CITY OF PORTLAND, MAINE
HISTORIC PRESERVATION BOARD

June 21, 2013

Re: Storefront Alterations; 15 Exchange Street

APPLICATION TO SWAP

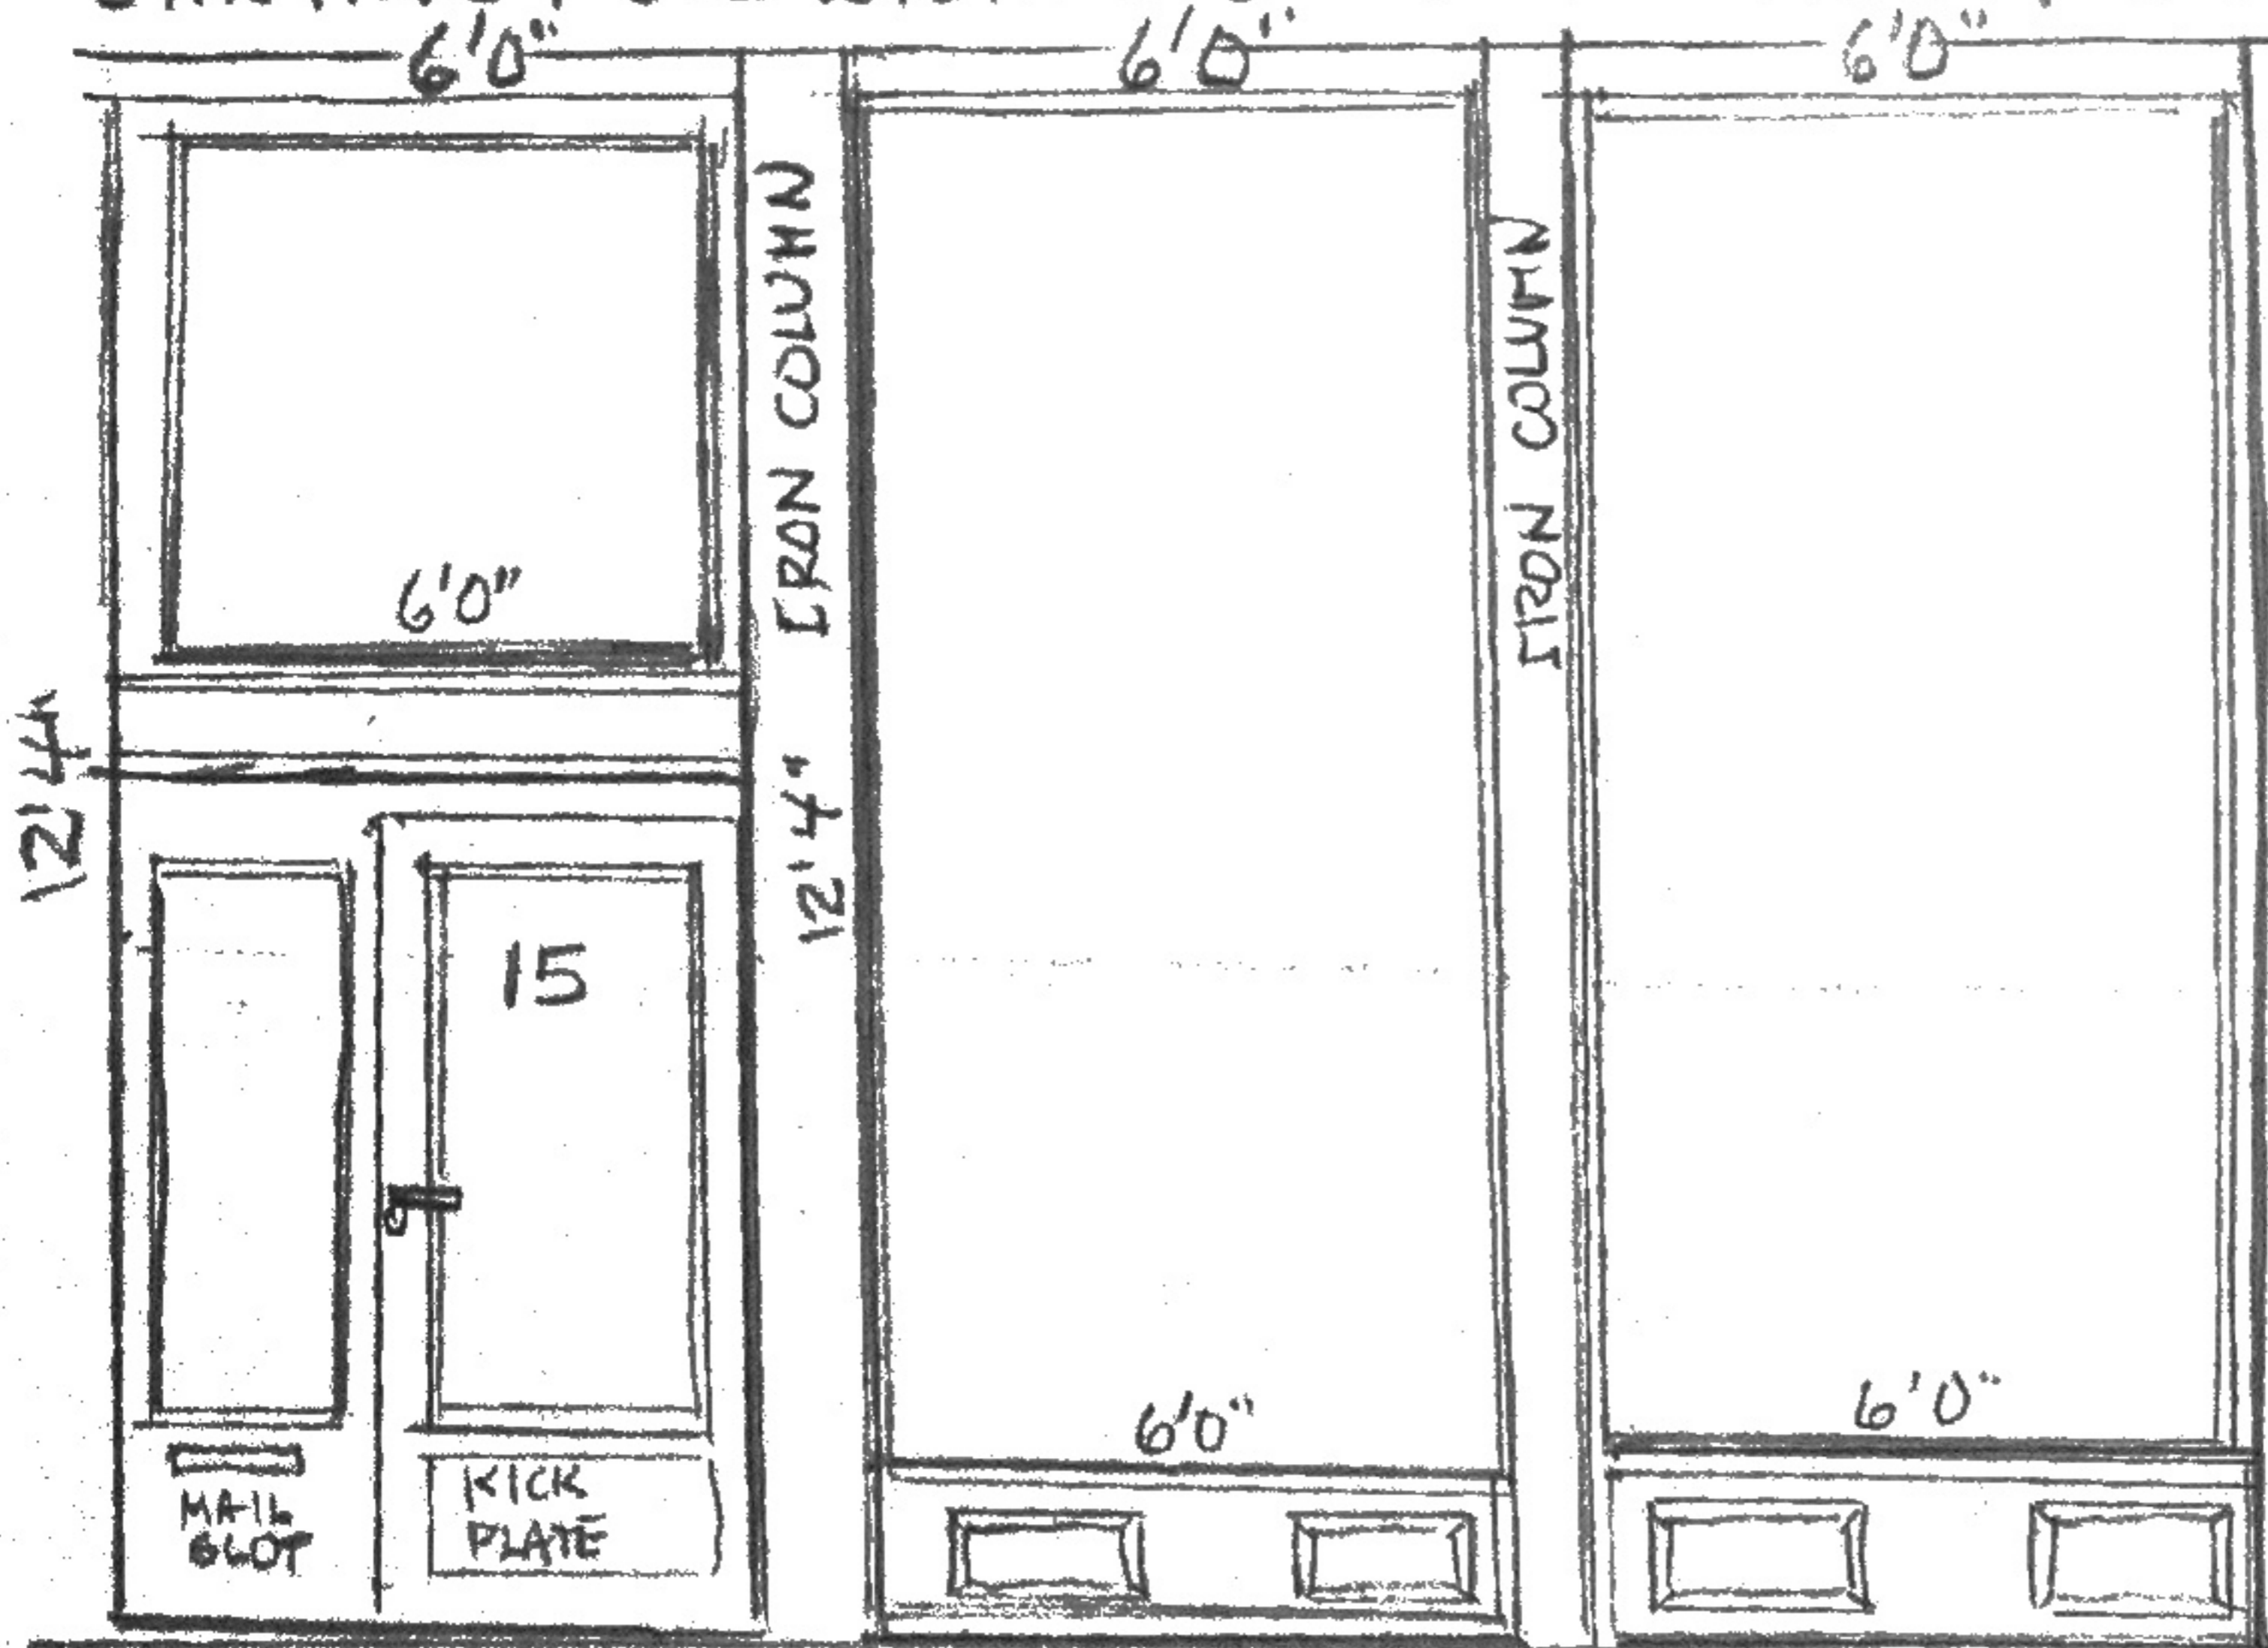
- All trim profiles and frame details to match details of remaining unaltered storefront bay.
- Final finish material and construction details of entrance threshold to be reviewed and approved by HP staff. (The Board recommends installation of granite or tile, consistent with threshold surface materials in the vicinity)
- Any additional lighting to be reviewed and approved by HP staff. Existing floodlights mounted on cast iron columns to be removed.
- Applicant to arrange for series of mid-construction inspections to ensure conformance with conditions and quality workmanship. (Call Rob Wiener, Preservation Compliance Coordinator, at 756-8023.)
